Recommendation: Approve

Applicant: My Ryan Breslin

Proposal: Two storey detached replacement dwelling with semi basement

drwg no 253\_04\_301 rev P4  
title Proposed Elevations II  
scale 1:100 @ A3

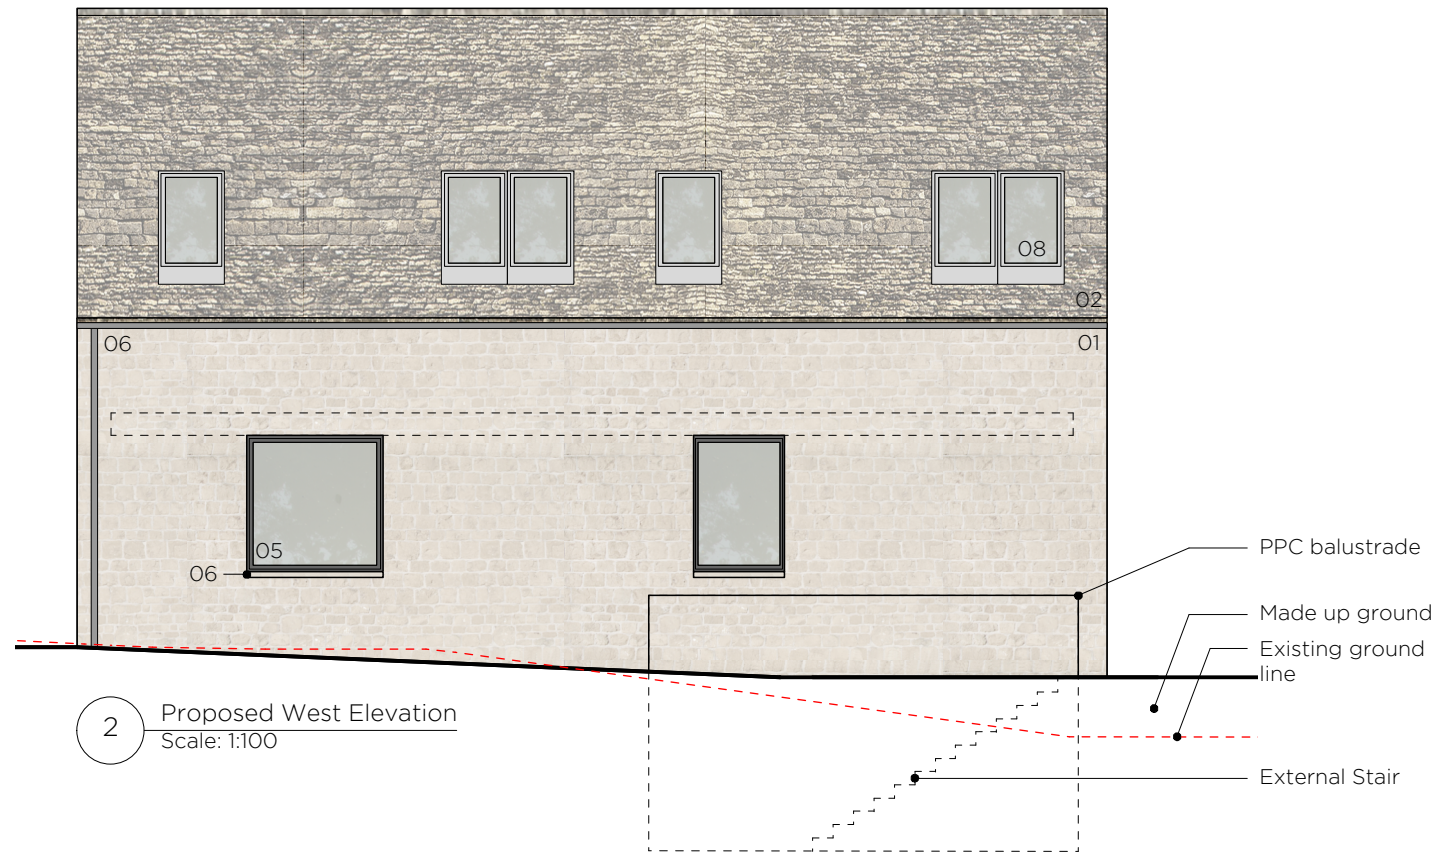
- 8.19. The dwelling is located between two other residential properties. The proposed dwelling would have windows on the first floor on both side elevations. These windows would be secondary windows to the rooms they serve and can be conditioned to be obscurely glazed.

8. Prior to the first occupation of the development hereby approved, the first floor windows (Bedroom 3 and Bedroom 4) in the east elevation of the dwelling shall be fixed shut, other than the top hung opening element, and shall be fully glazed with obscured glass (at least Level 3 only) that complies with the current British Standard and shall be retained as such thereafter.
